Application No: EP/65/20/HH
Site Address: Highbeach House 9A Tamarisk Way East Preston BN16 2TF
Description of works: Demolition of existing conservatory and construction of new rear 2 storey extension and replacement orangery, replacement dormer and 3No. new rooflights.

Thank you for your internet representation made on 15th July 2020 which has been recorded as no objection with the comments as follows:

20207 SK10C
Highbeach House, 9a Tamarisk Way
Second Floor Plan as Proposed
Scale 1:100

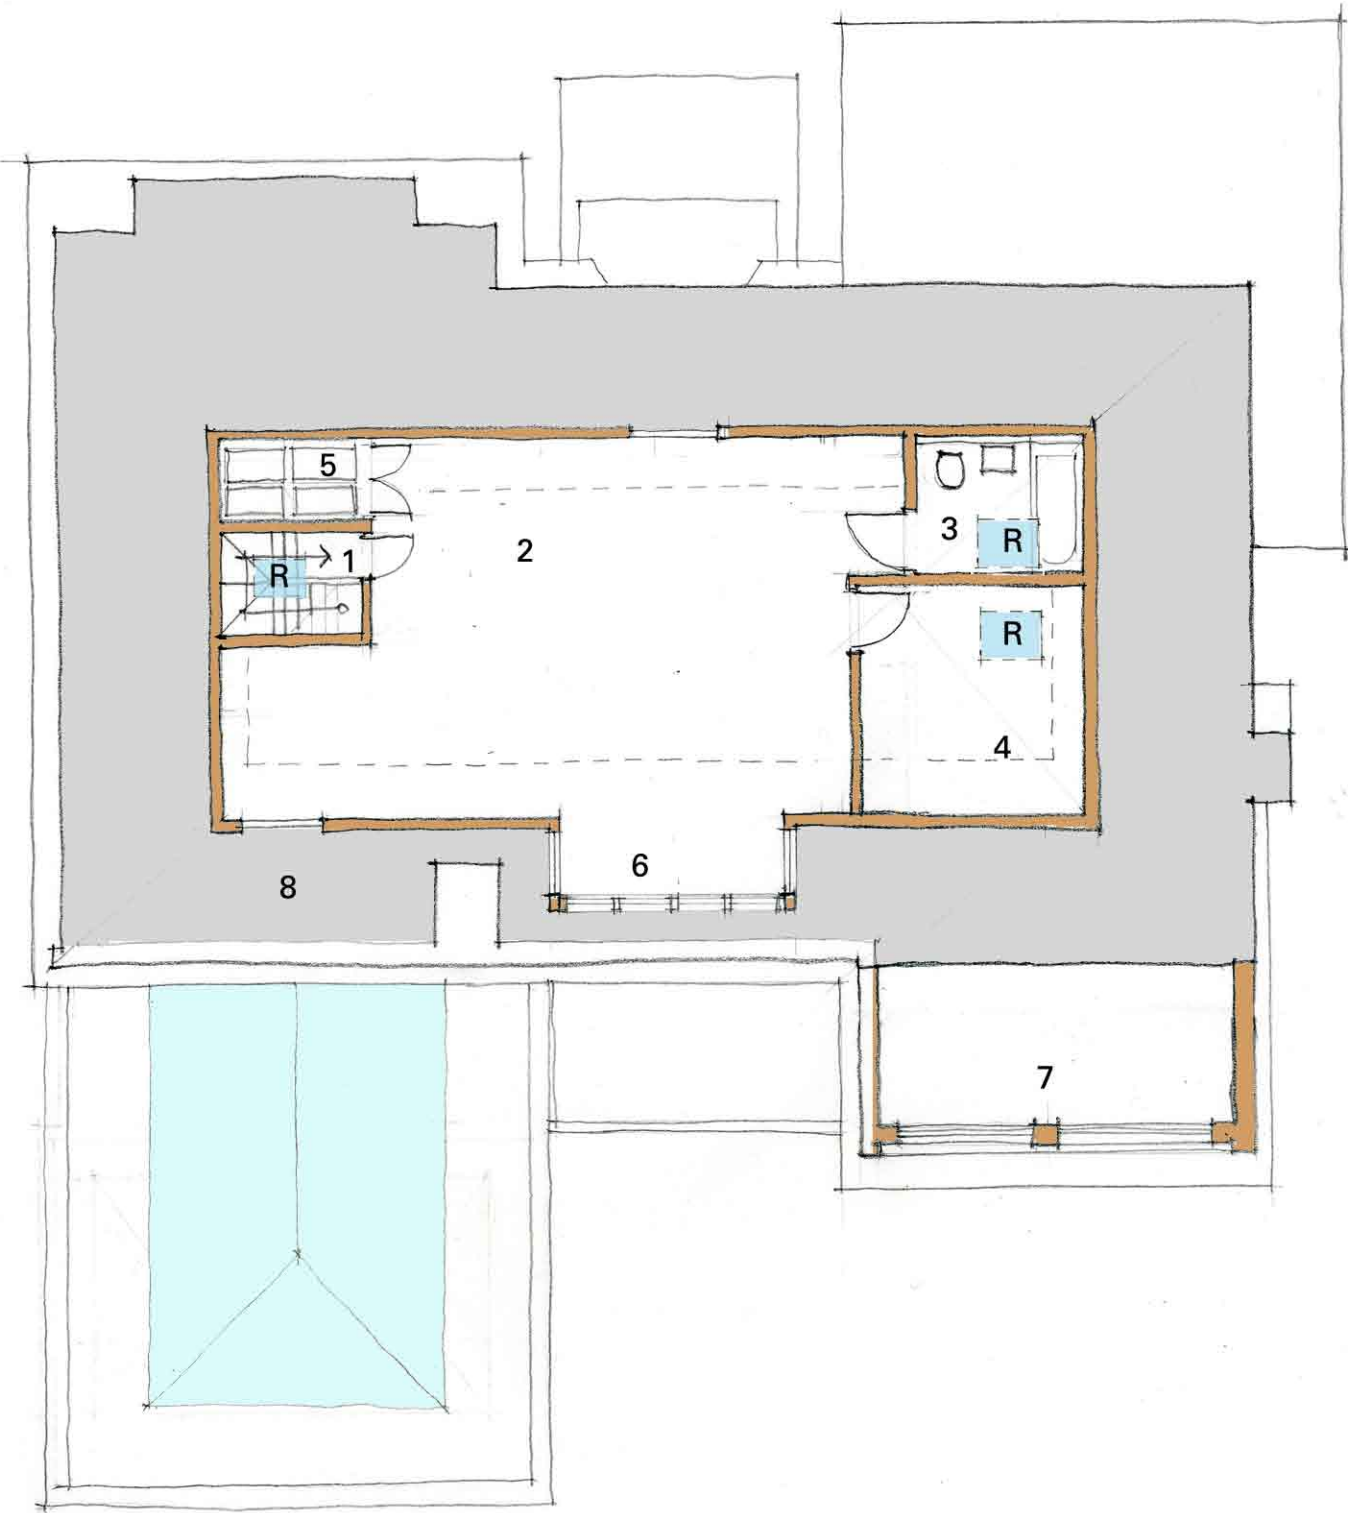
The committee agreed not to raise any objections to this Application, although there were concerns raised that the Application could be contrary to the East Preston Neighbourhood Plan as the glazed gable end and the enlarged dormer will change the view from the beach.
